Date:	12/6/16	Review Agency:	State Engineer
File Number:	SF-16-021, PUDSP-16-004	Reviewer:	_____
		Project Manager:	Nina Ruiz (719) 520-6313
Send response comments to: <u>DSDcomments@elpasoco.com</u>			
Project Name:	North Bay at Lake Woodmoor Final Plat, Preliminary Plan, Planned Unit Development		
Request:	A request by Lake Woodmoor Holdings LLC for a final plat to create 28 townhome lots, and 5 tracts on a 7.23 acre parcel presently zoned R-4 (obsolete). A PUD/preliminary plan is being processed concurrently. The applicants have requested a CLOMR from FEMA to realign the floodplain to that which is shown on the final plat drawing.		
Commissioner Dist:	1		
Tax ID# (s):	71114-04-111, 71114-00-007

Re: North Bay at Lake Woodmoor – PUD Development Plan and Final Plat

Subject: Northbay at Lake Woodmoor, SF-16-021, Review 1

SHEET
13
13 of 18 Sheets

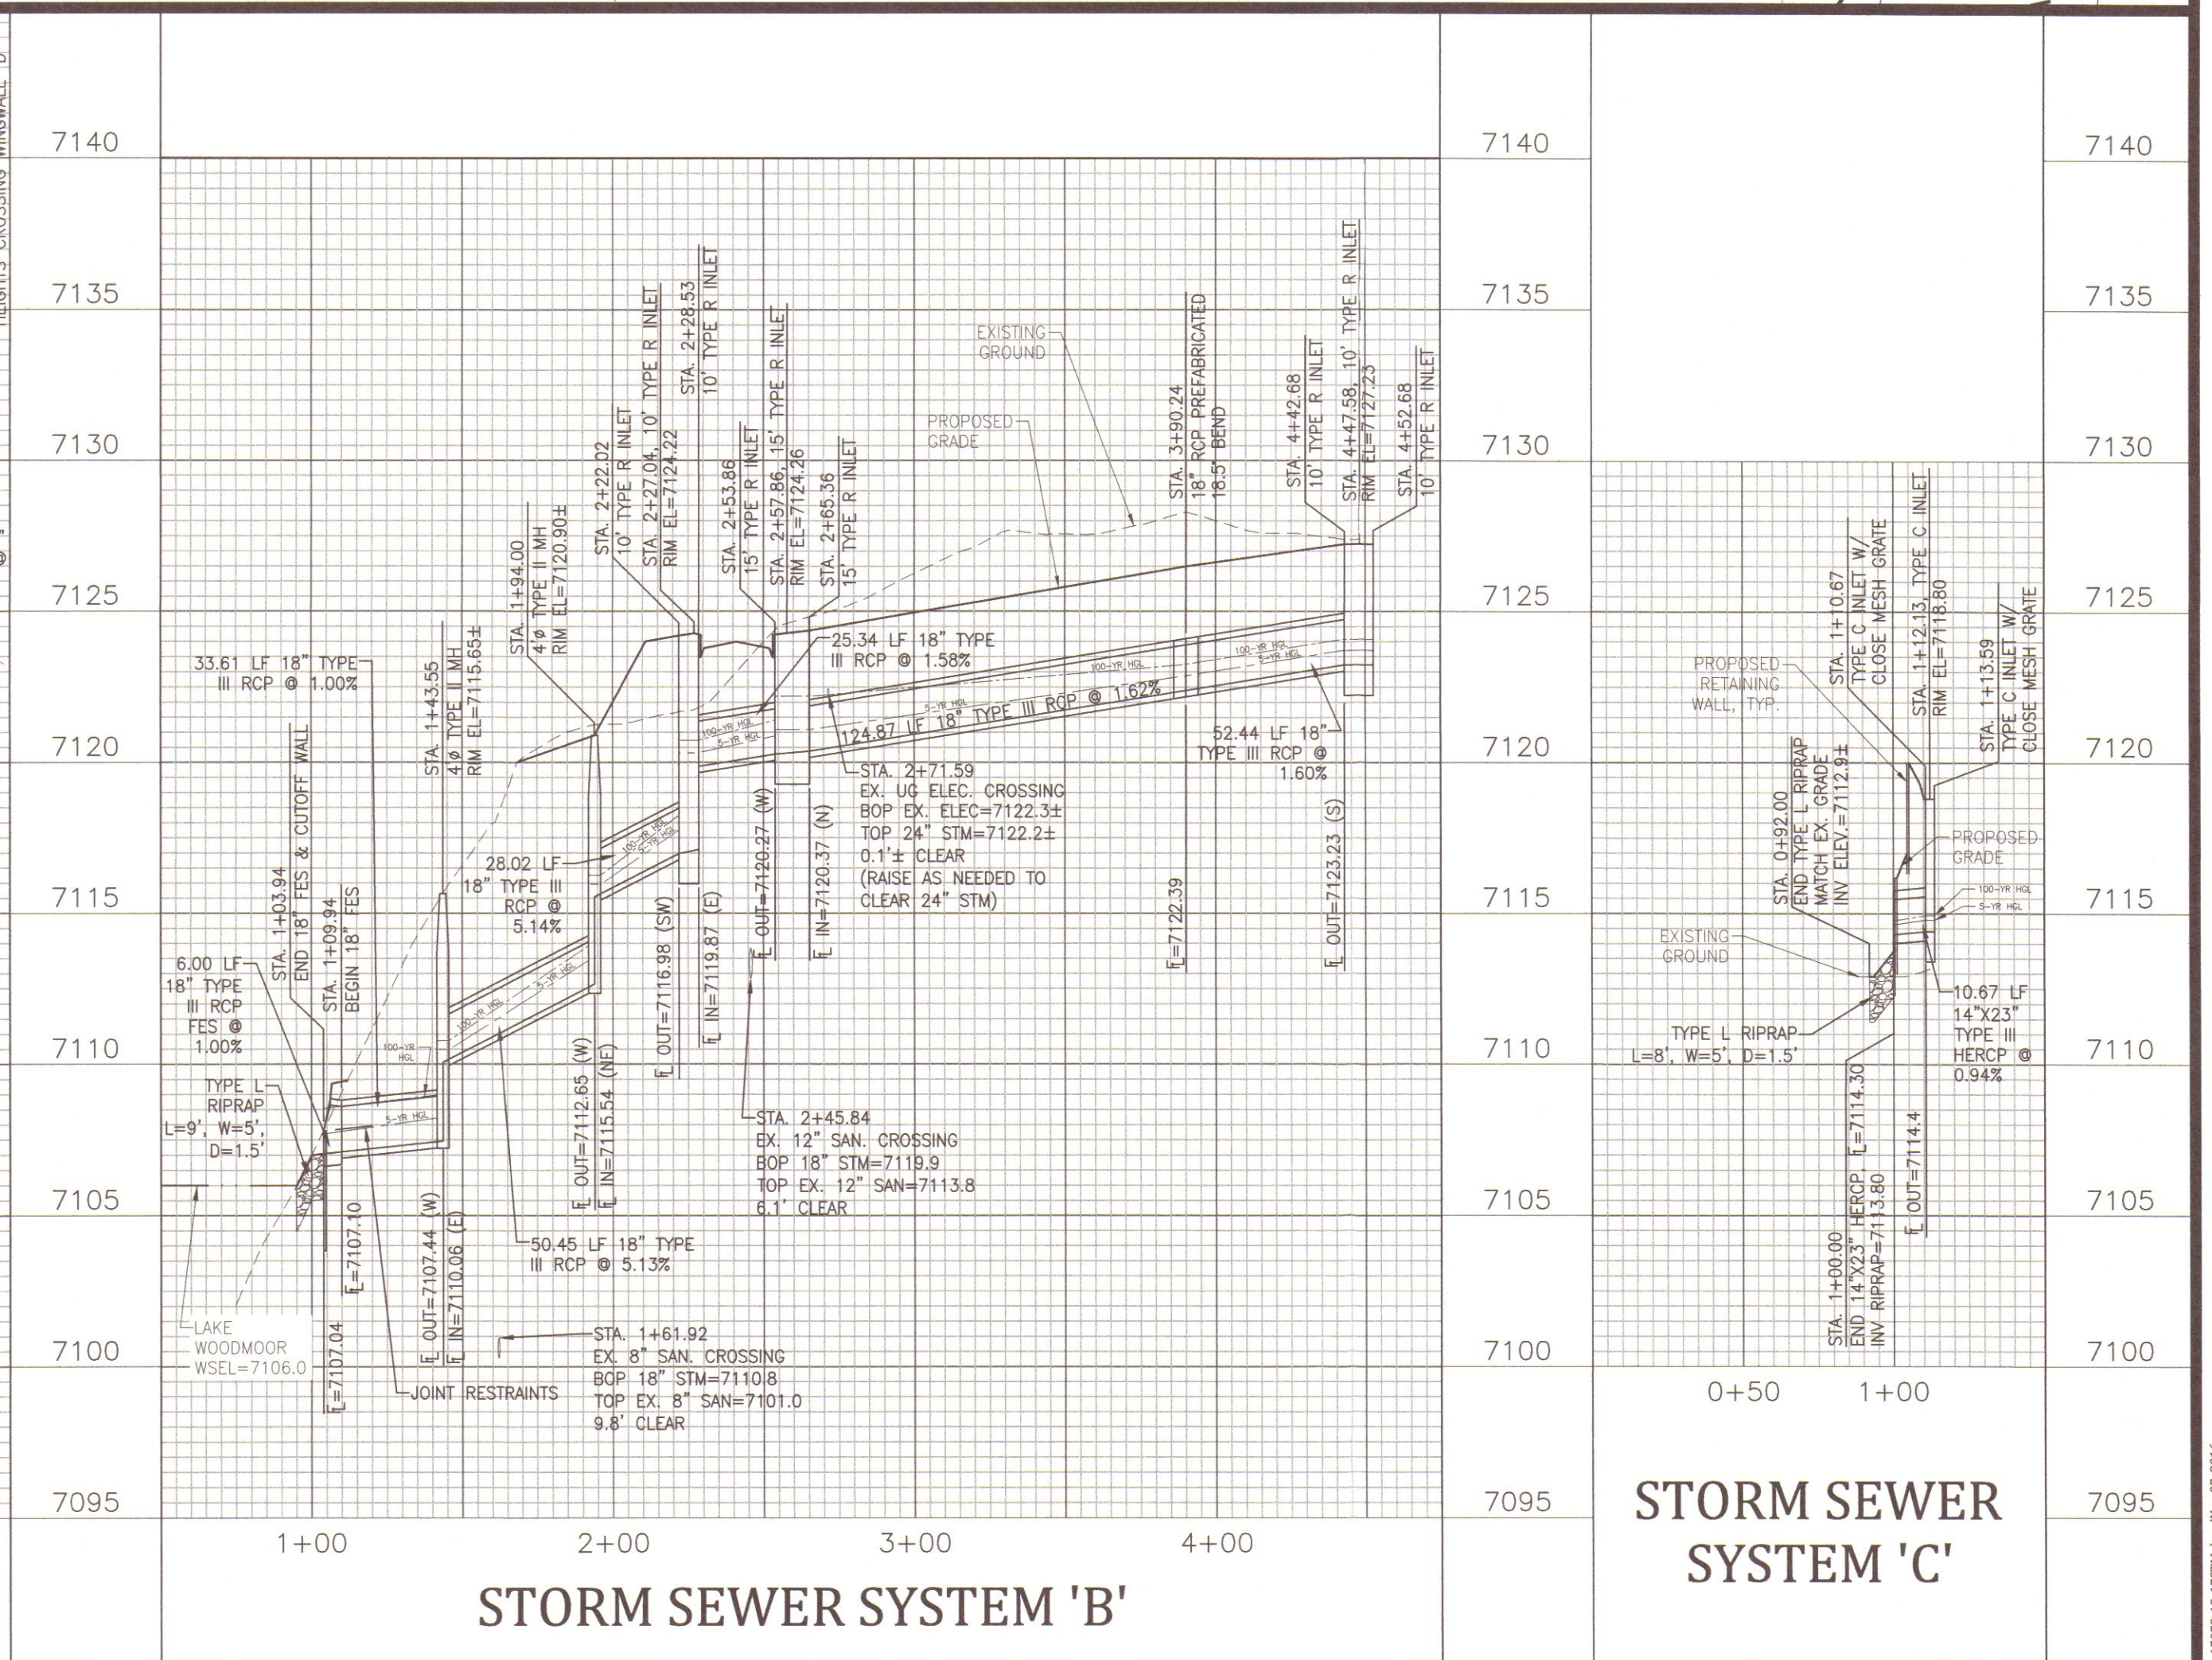
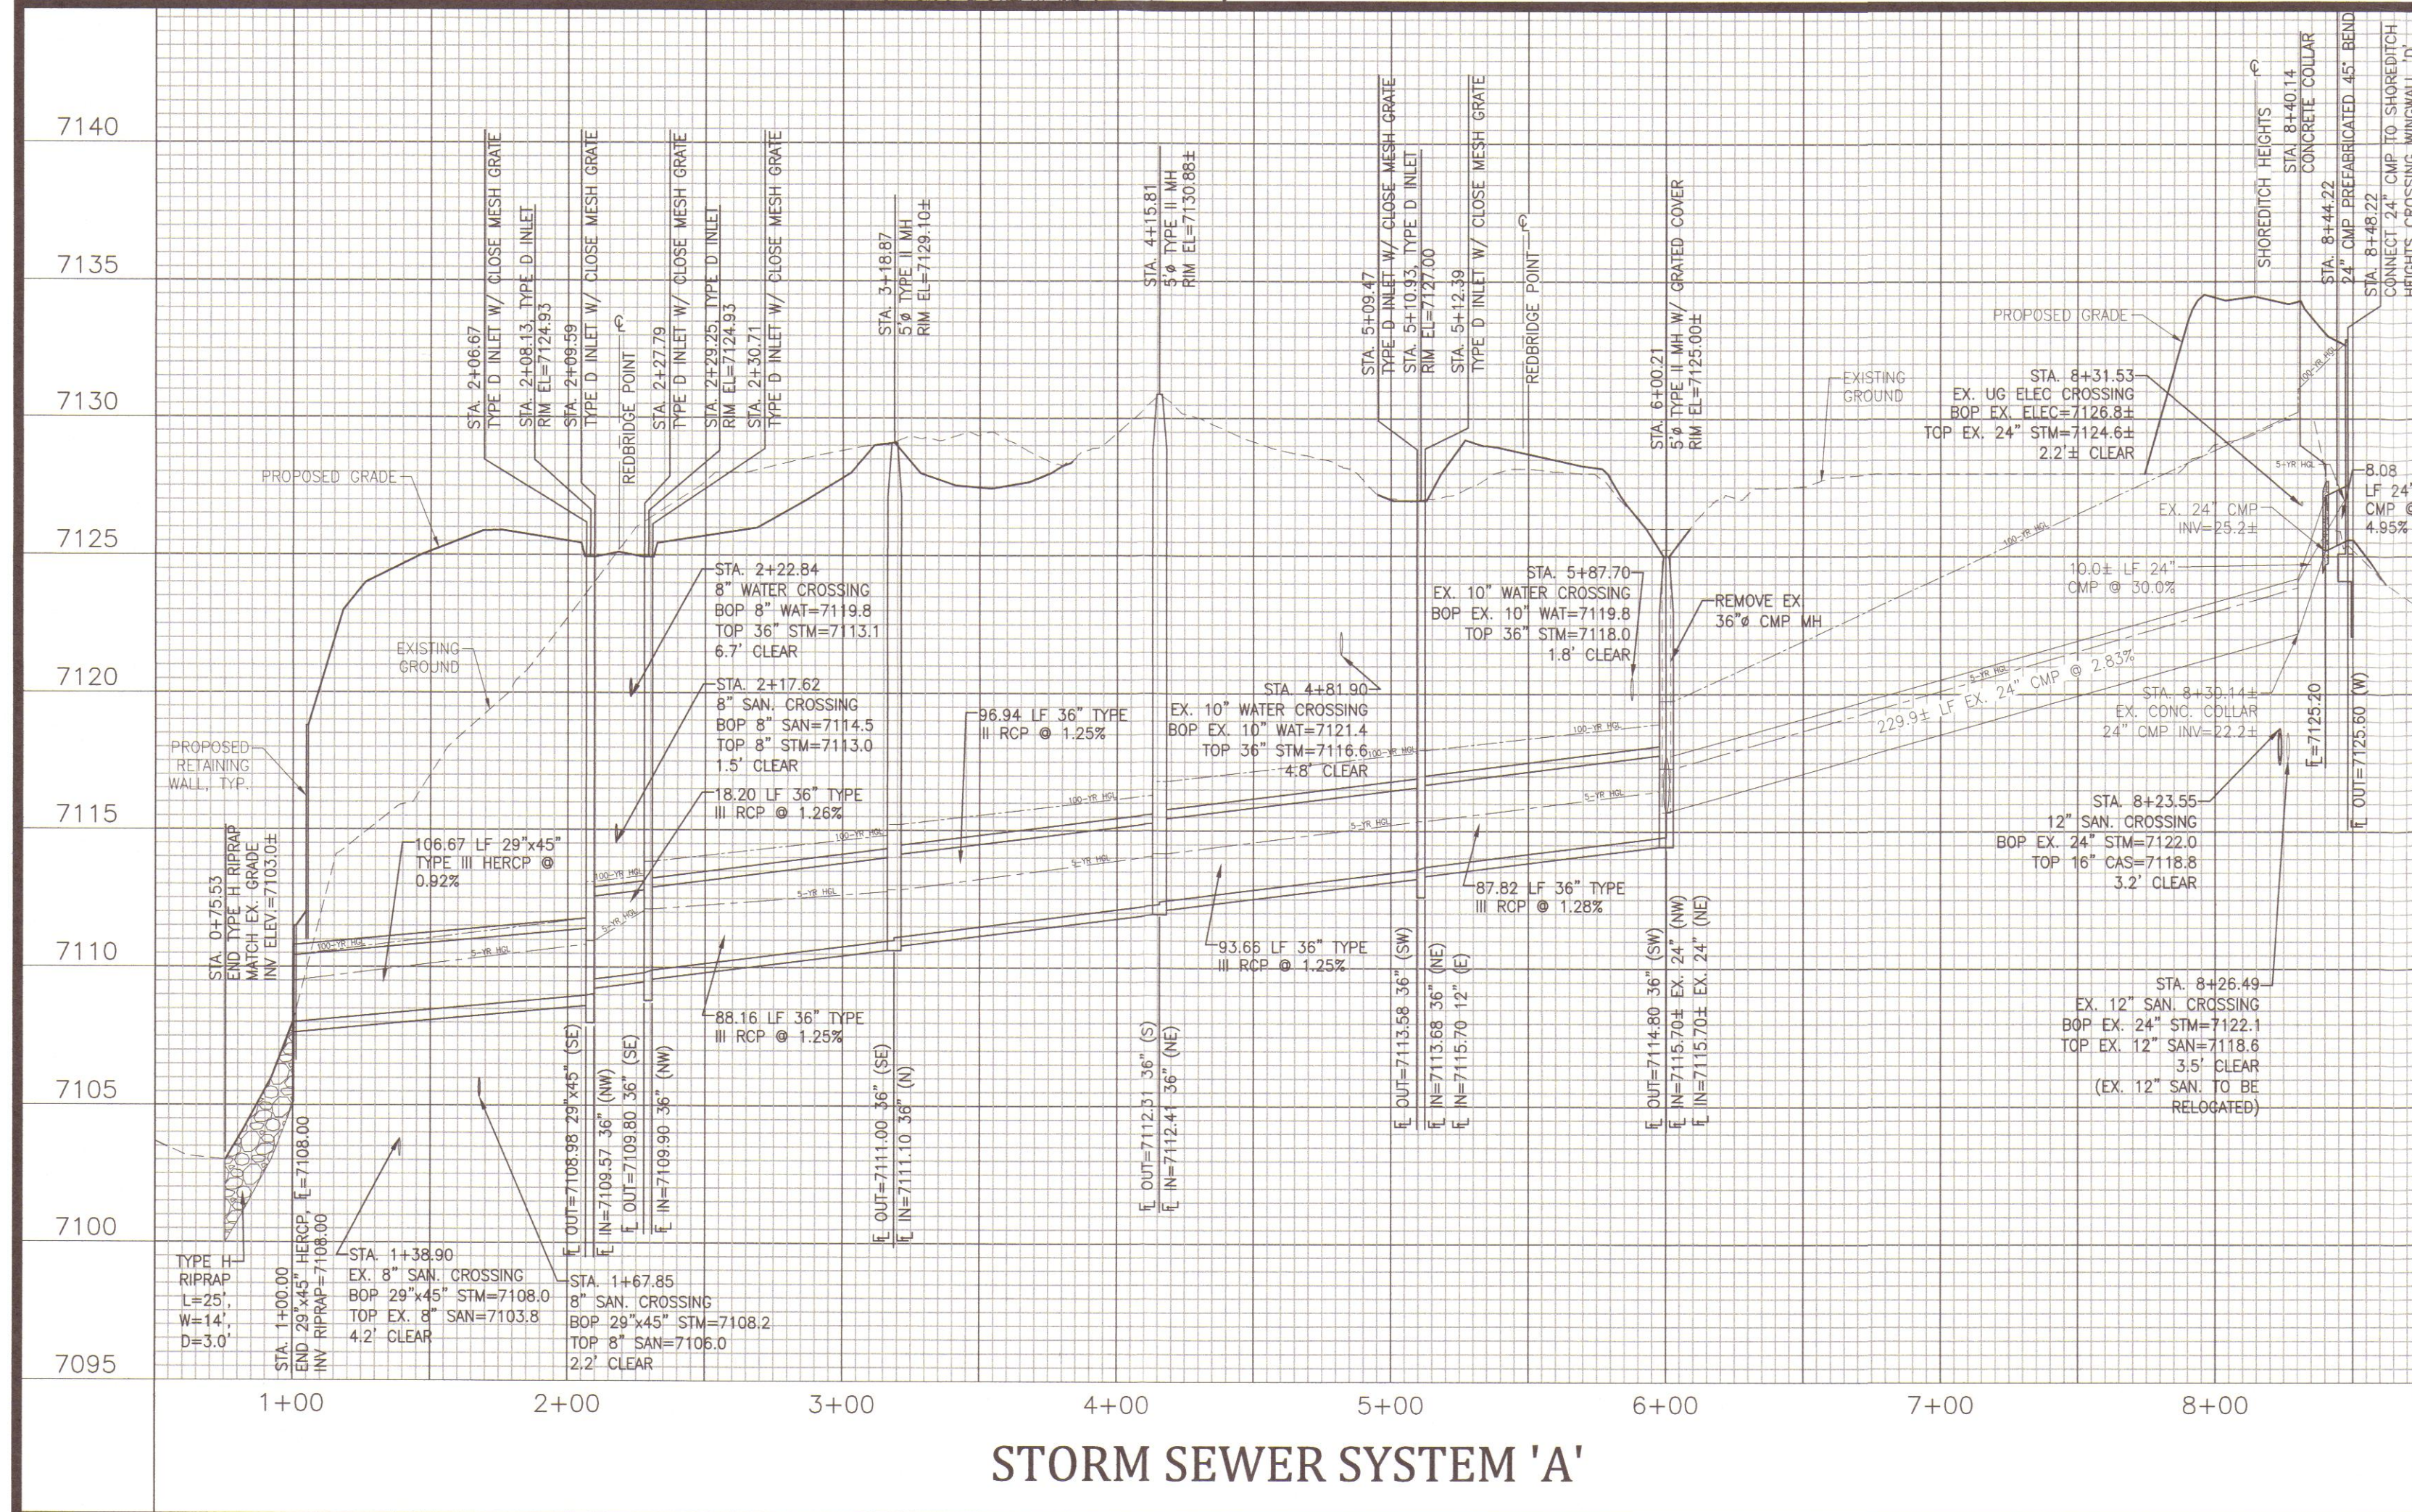
6. Storm P&P sheets (13 & 14)
 - a. Show the proposed lot lines.
 - b. Label the storm sewer systems and check structures as Private.
 - c. Place the segment of Storm System 'A' going through Lot 17 in an easement.
